Date: 12 August 2021
Our ref: 359197
Your ref: P/93/21/PL

Planning consultation: Creating a temporary alternative outflow channel to reduce/avoid flood and erosion risk to properties and businesses at Pagham Beach and Haven Church Farm over the autumn 2021. This application is the subject of an Environmental Statement & is in CIL Zone 5 (Zero Rated) as other development.

Location: Church Norton Spit Pagham Beach Pagham PO21 4TD

Drawing B

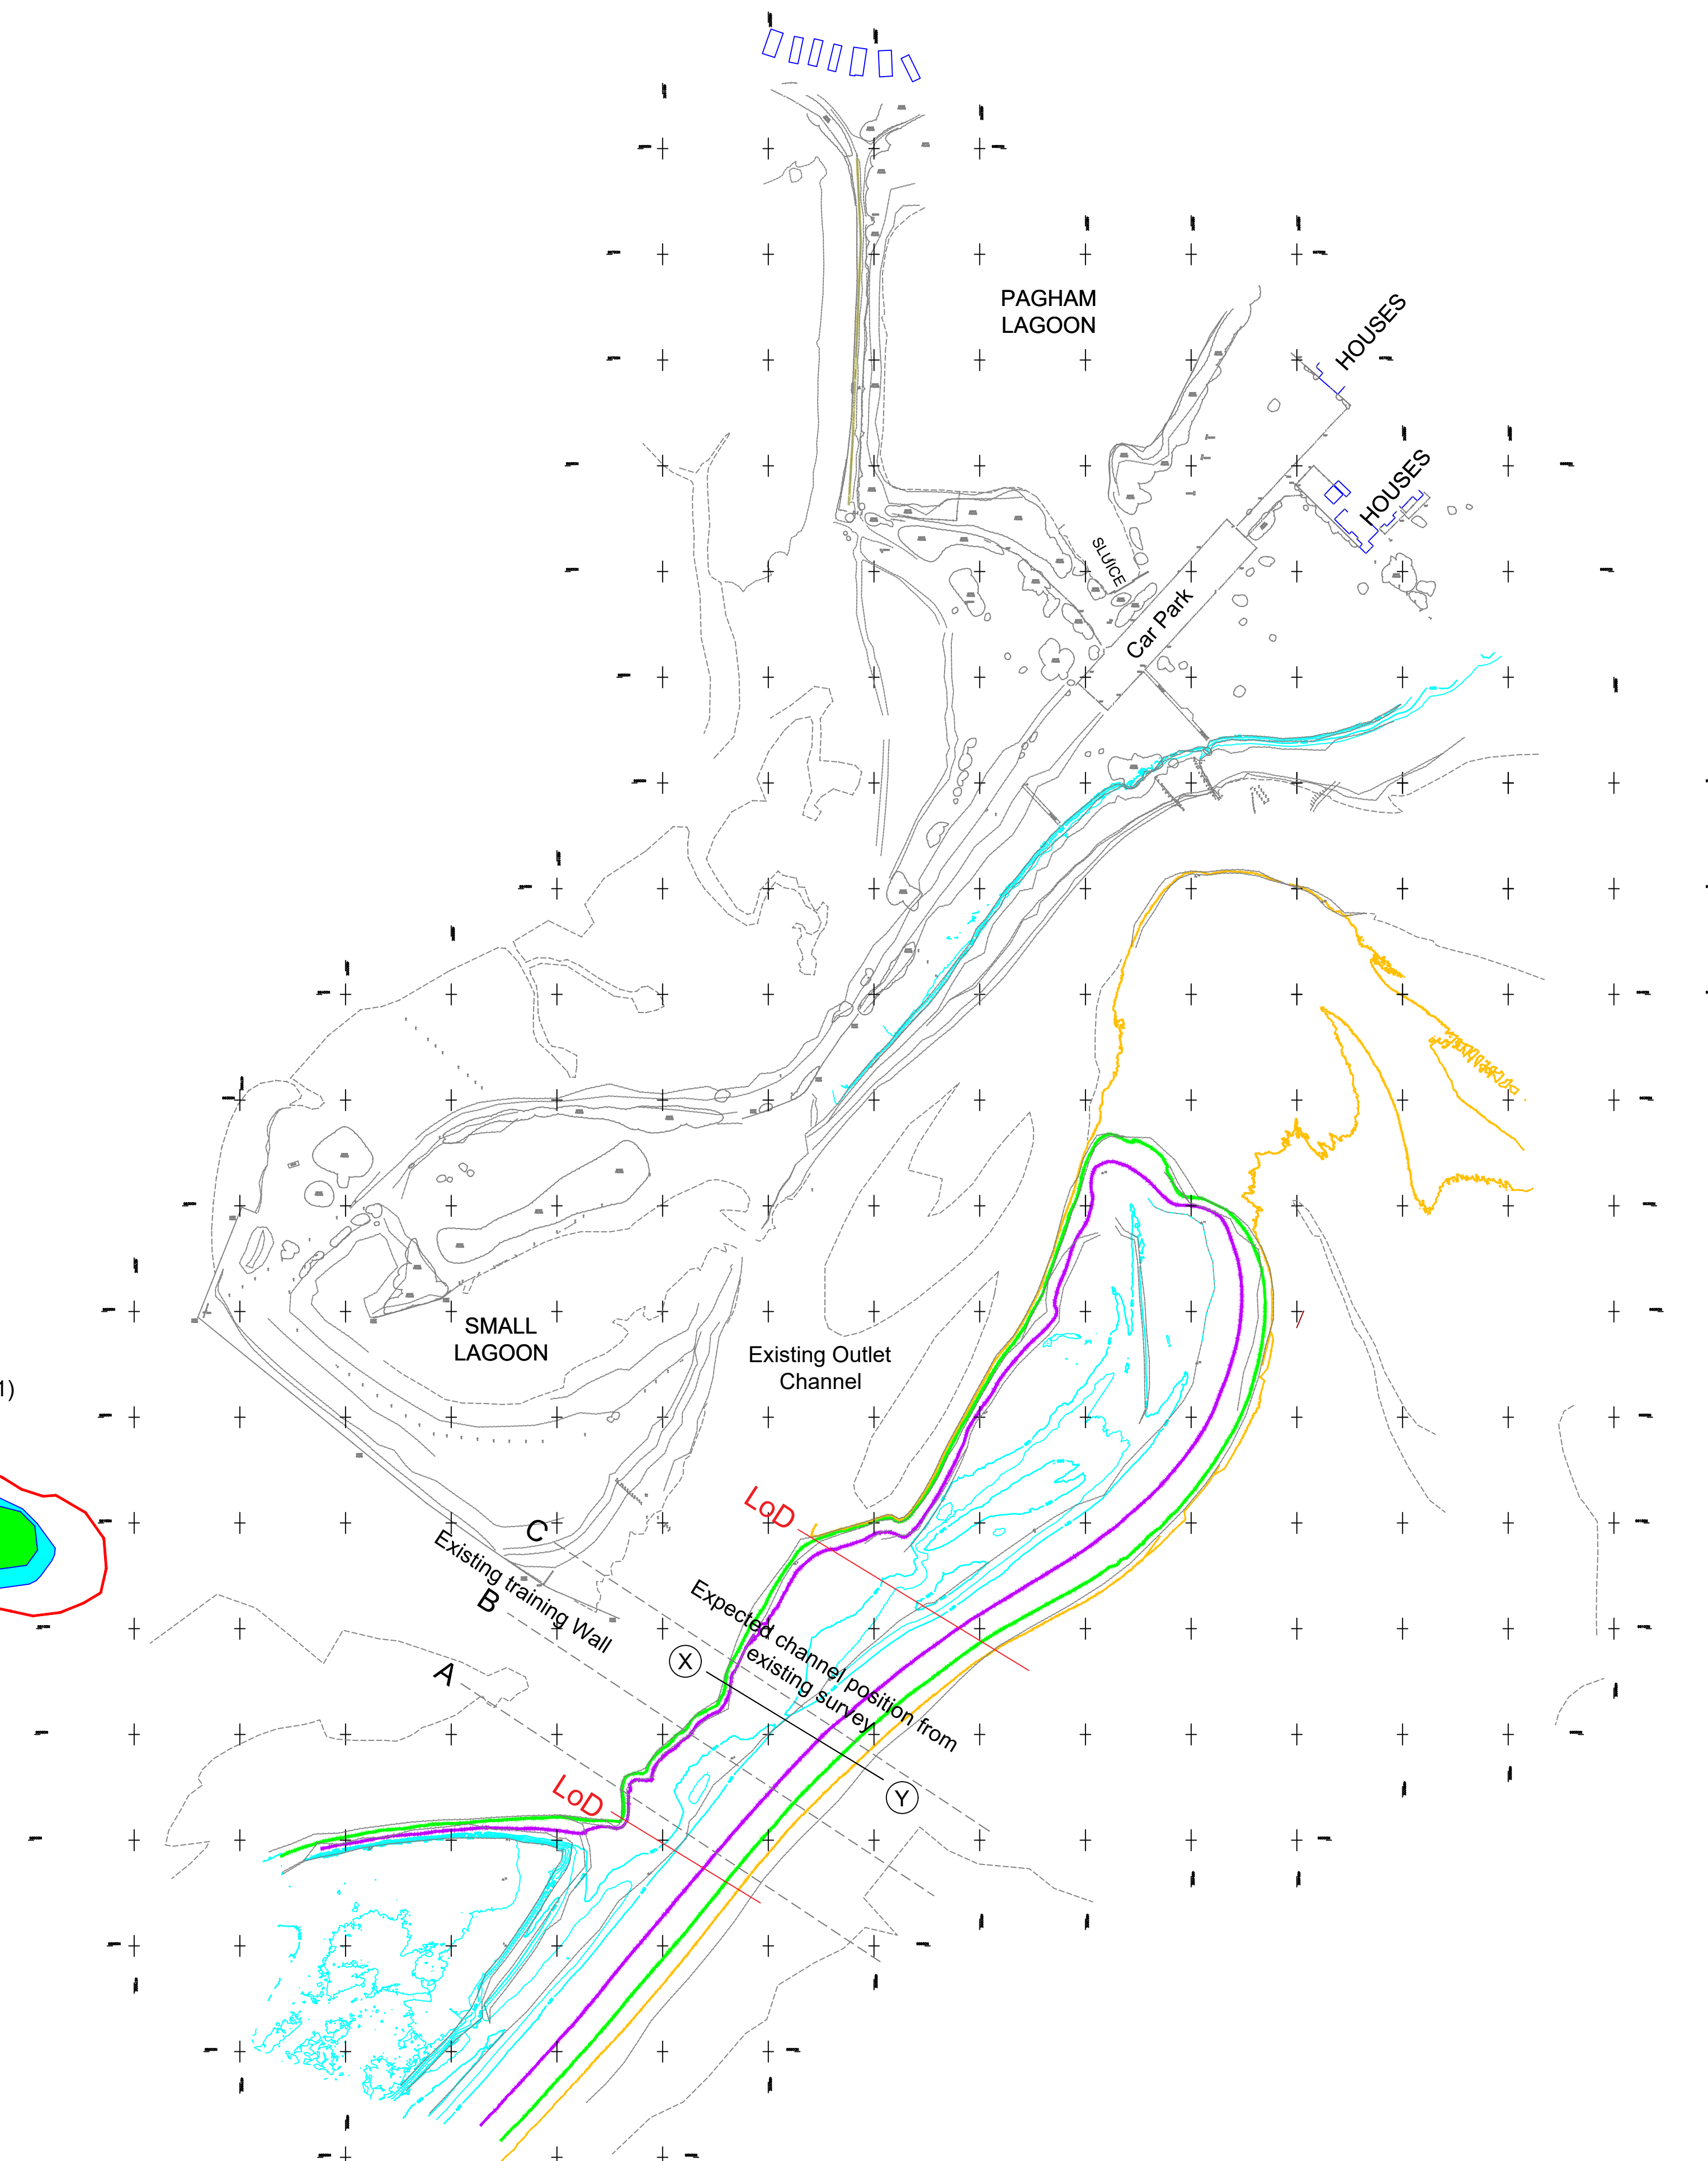
Since the previous planning application (P/97/15/PL), an alternative location for little tern compensatory habitat has been proposed. This involves the creation of an artificial, 0.3ha island opposite the harbour mouth, created from approximately 3000m³ of shingle excavated from the spit. Natural England has worked closely with the applicant via the Pagham Coastal Issues Advisory Group (PCIAG) to design the alternative compensatory habitat and ensure that it is suitable to accommodate the little tern breeding colony.

If the island erodes and the spit has not regrown, the island must be recharged prior to the nesting season. However, shingle to recharge the island must not come from within the SPA.

Drawing A

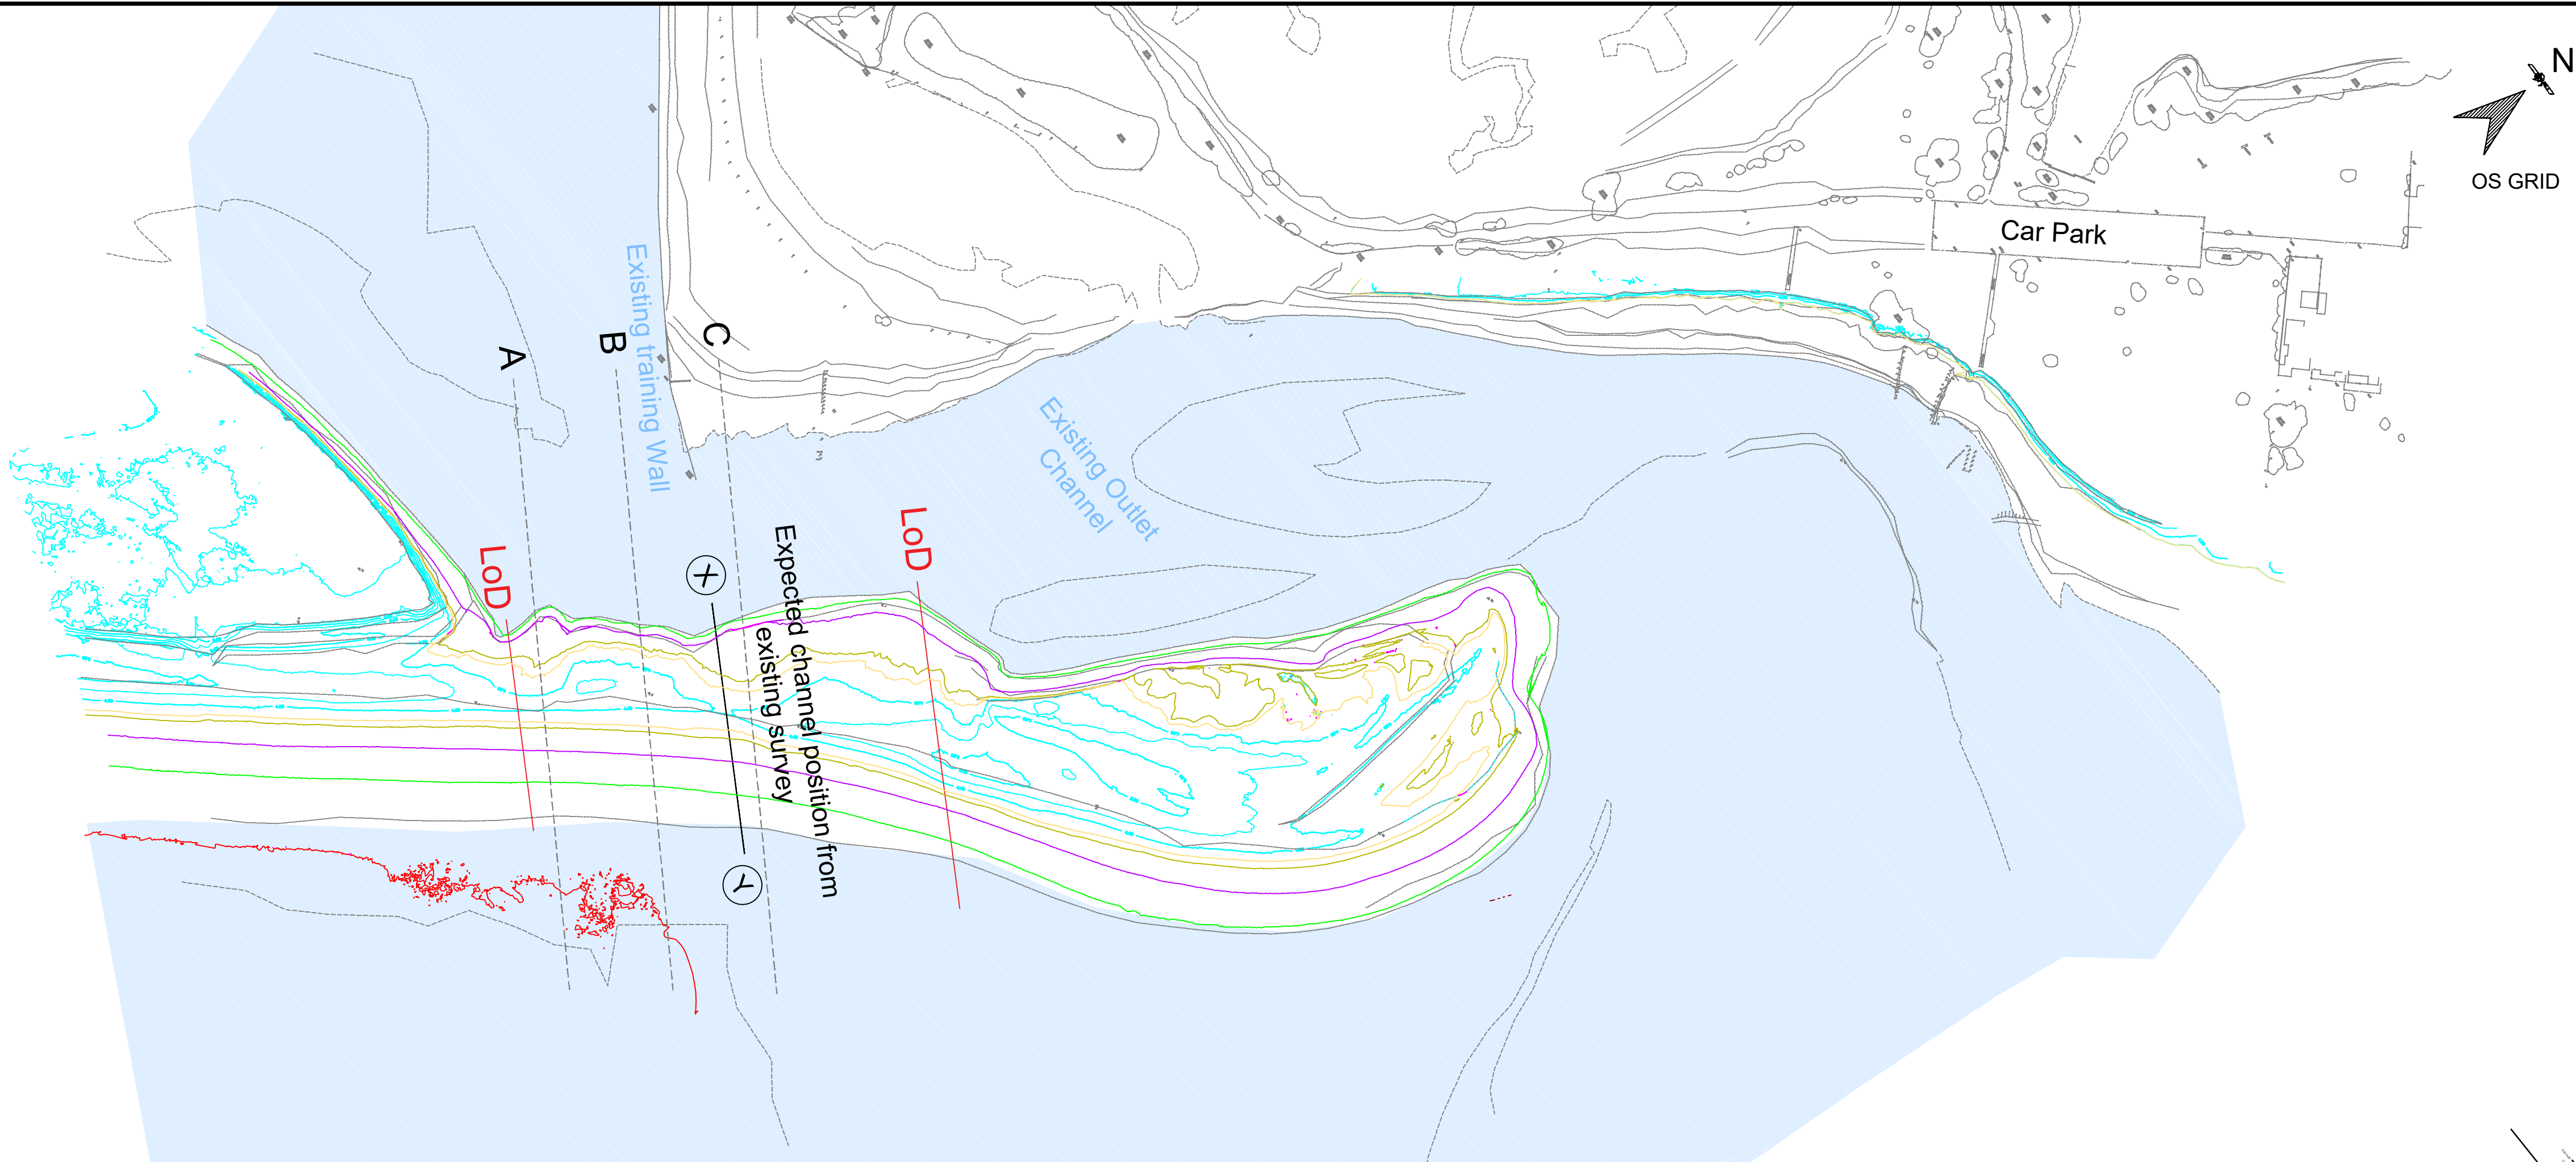
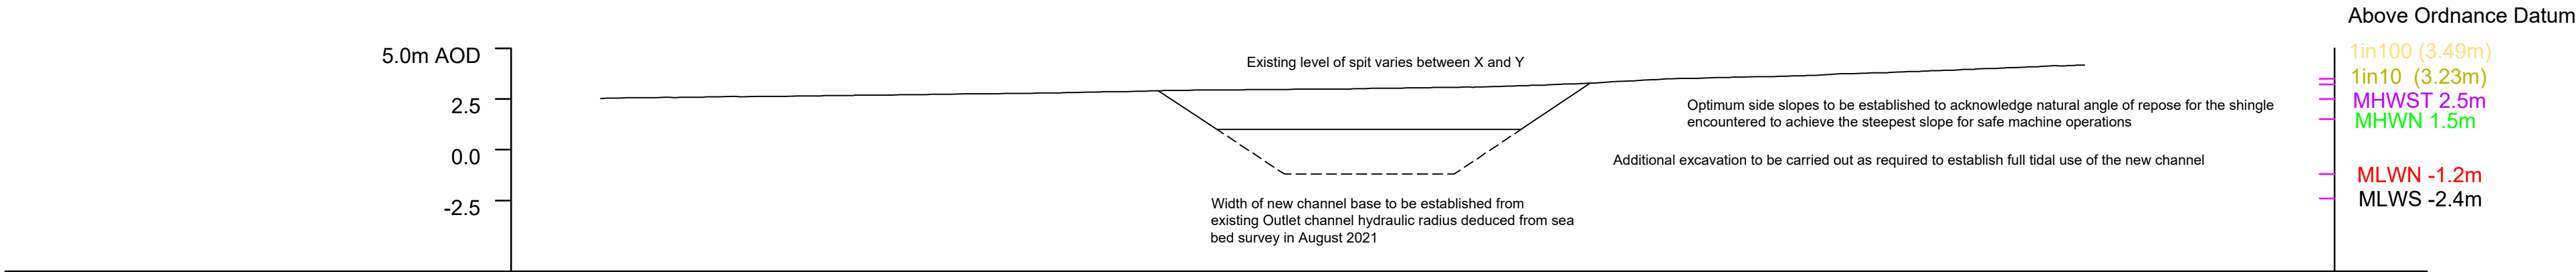
The existing shingle spit at Pagham Harbour provides the main nesting area for little terns, and currently supports 19 breeding pairs. The cutting of the spit would result in a direct loss to little tern breeding habitat, therefore the application has proposed the creation of compensatory little tern breeding habitat within the site.

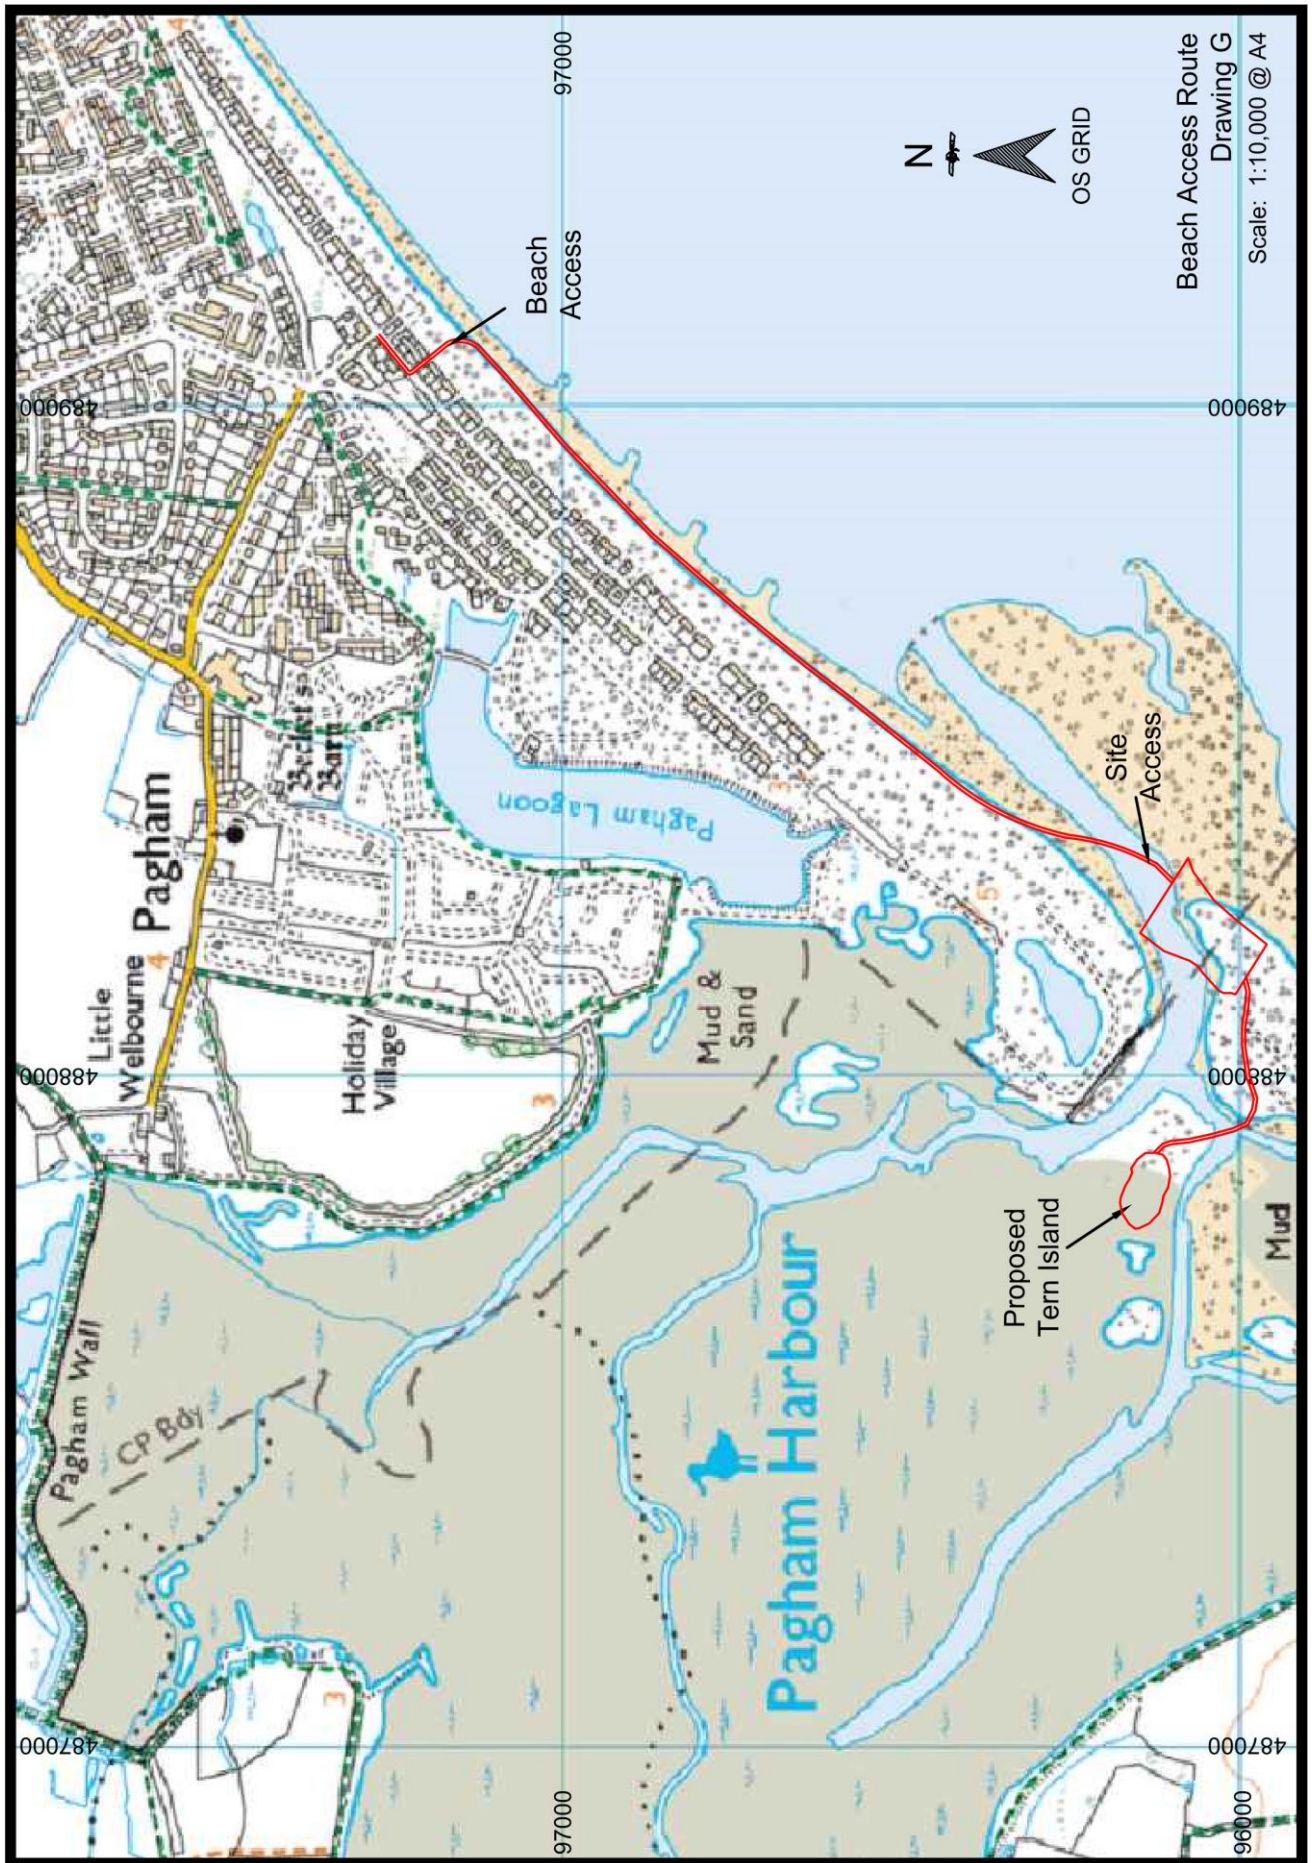
The construction phase of the proposal, without suitable mitigation is likely to cause damage to vegetated shingle, which is a feature of the SSSI. Natural England note that mitigation measures for vegetative shingle outlined in the previous application should be applied to this application. Where possible, heavy machinery and construction personnel should avoid trampling/travelling over vegetative shingle vegetation. This can be achieved/minimised by methods of access and routing, including the use of designated pathways/tracks, or within the intertidal zone to ensure minimum impact on shingle ridges and vegetated shingle. Matting should be used if crossing over vegetative shingle cannot be avoided.
